**WELWYN HATFIELD COUNCIL – DEVELOPMENT CONTROL**  
**DELEGATED REPORT**

<b>APPLICATION No:</b>	<b>S6/2008/714/FP</b>
------------------------	-----------------------

This application seeks full planning permission for the erection of a single storey front extension. The proposed extension measures 5.4m width x 1.5m depth and would replace the existing bay window and porch. The proposed extension would feature a hipped roof approximately 4.8m in height and a bay window and arched porch similar in design to the existing. All external finishes are to match existing.

CLIENT	F Greaves Esq.
PROJECT TITLE	15 Theobalds Road, Cuffley
DRAWING TITLE	Existing & Proposed Elevations

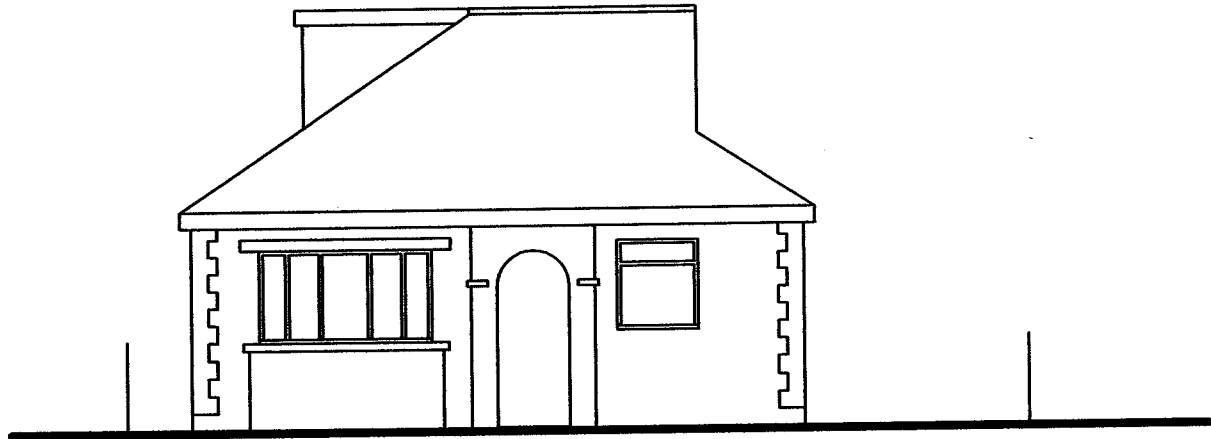
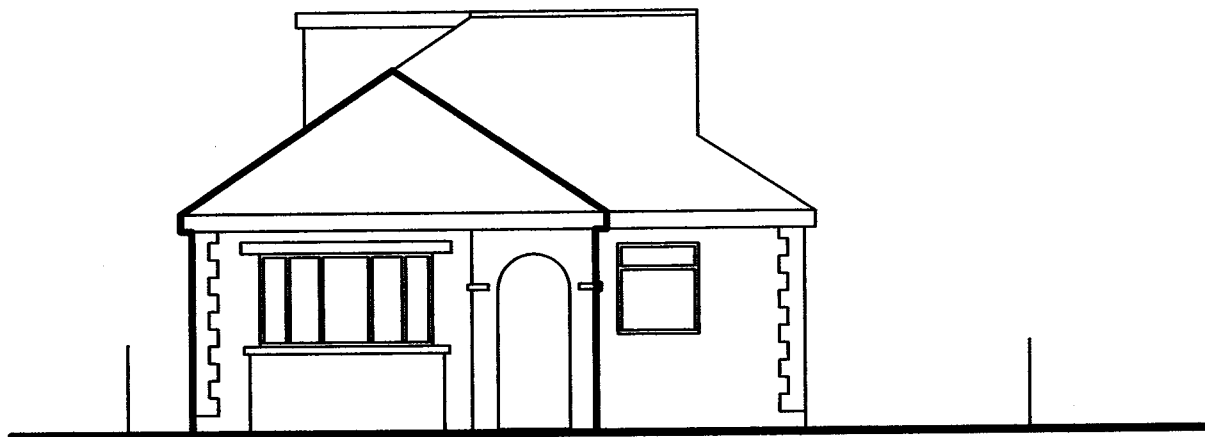
Following refusal of planning application S6/2007/1648/FP, the scheme has been redesigned to compliment and reflect the character of the existing bungalow and other bungalow along Theobalds Road. In particular it is now proposed to finish the extension with a hipped roof as apposed to the previously proposed flat roof. The current scheme also replicates the existing bay window and arched porch which are key features of the existing bungalow.
